## KITTITAS COUNTY COMMUNITY DEVELOPMENT SERVICES

### **RE: Zoning Variance (VA-26-00002 Johnson) – Deemed Incomplete – Request for Additional Information**

Kittitas County Community Development Services (CDS) received your Zoning Variance application (VA-26-00002 Johnson) on February 25, 2026, for parcel 640236. Staff has reviewed your application and determined that more information is needed before this application can be processed any further. As such, Kittitas County declares your application incomplete as of February 26, 2026.

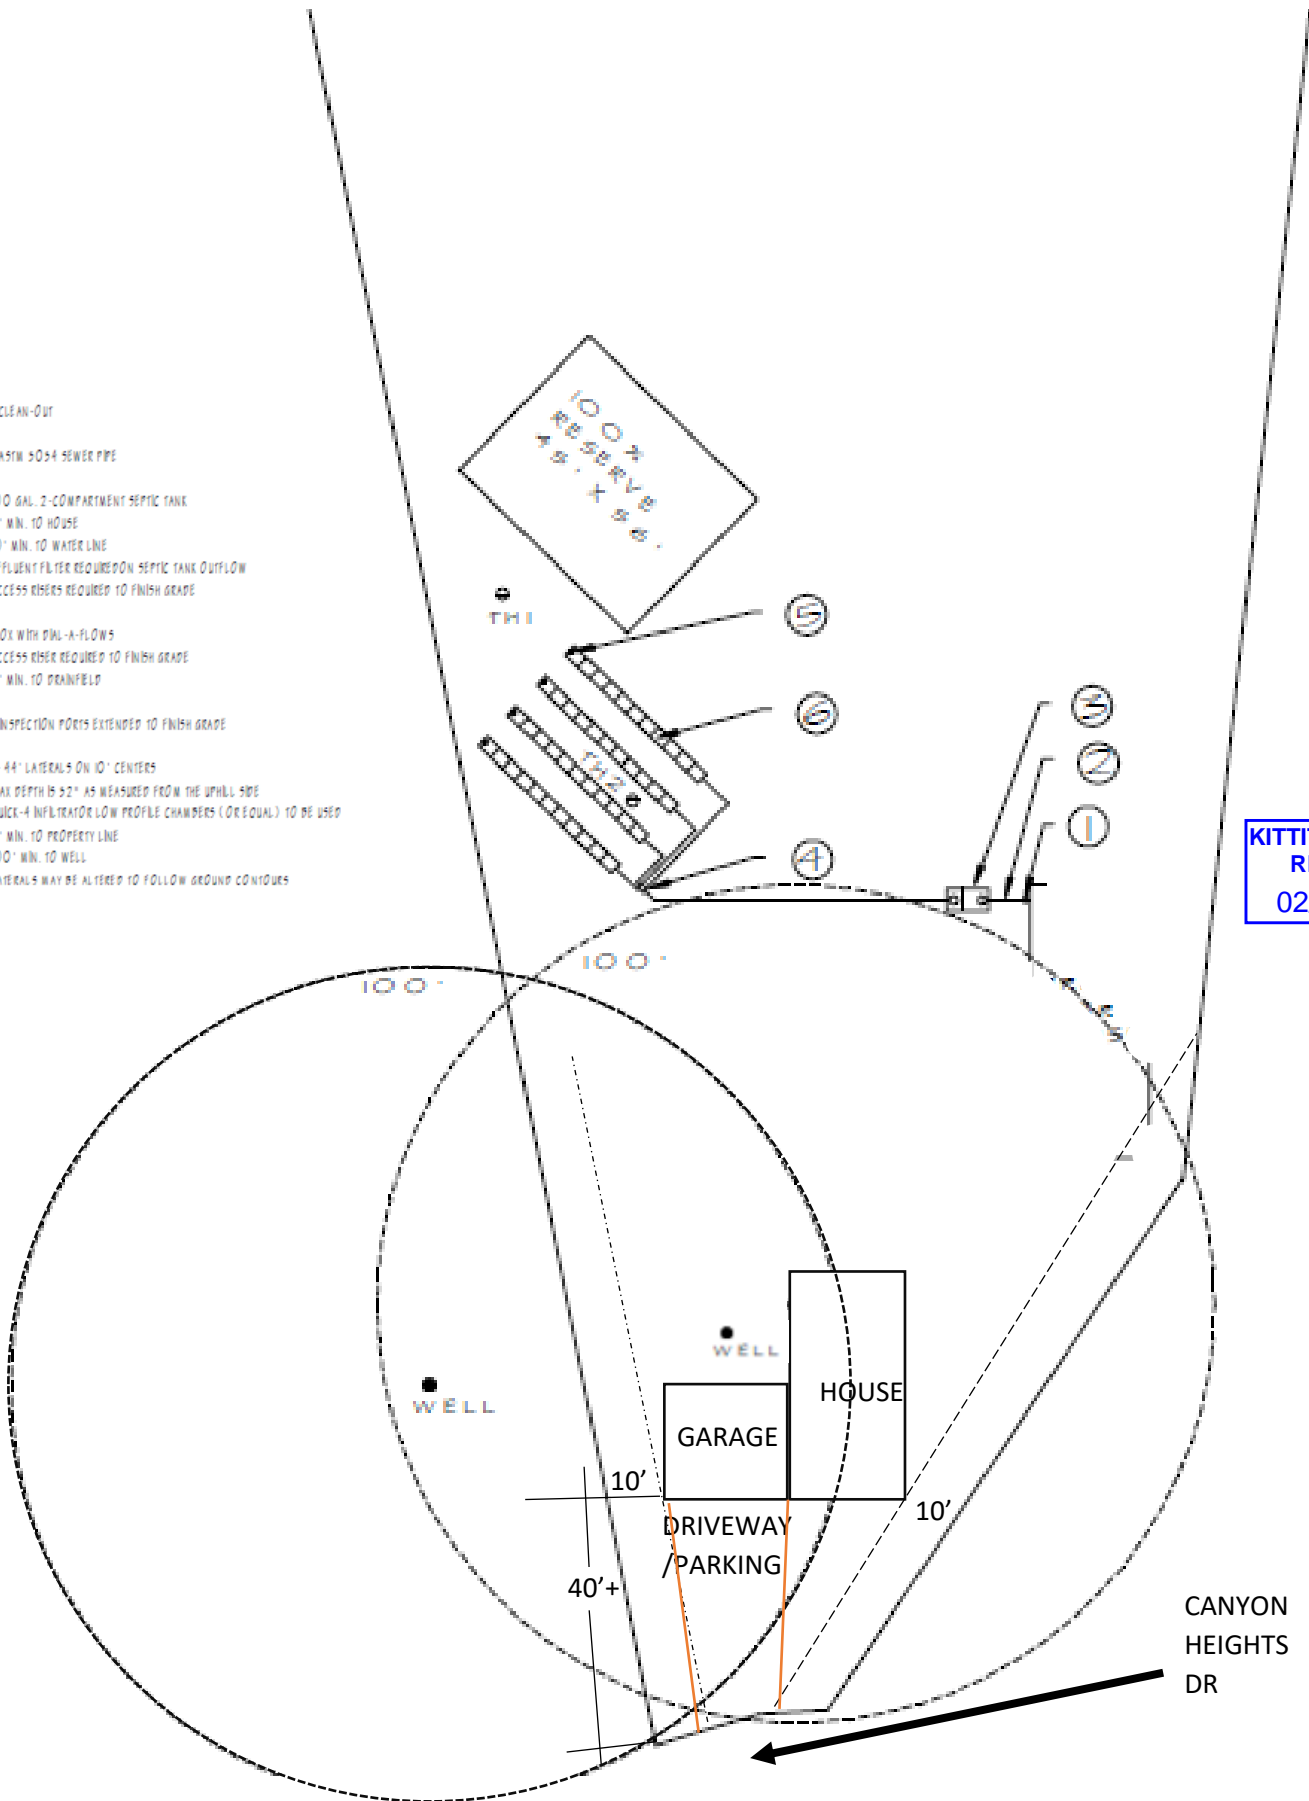
1. Please provide a scaled site plan showing the location of all structures, access points, roads, septic tank, drainfields, and the well location. Your site plan should also include natural features, such as slope contours etc.

The site plan provided appears to be a modified version of the plan submitted for the On-Site Sewage (OSS) permit. This site plan is not scaled and is insufficient for our Zoning Variance review.

Furthermore, upon review of the OSS and well permits submitted to Public Health, there appears to be a discrepancy regarding the well's location. Based on the request for a variance due to the well's location, please ensure that its position is accurately depicted on the site plan.
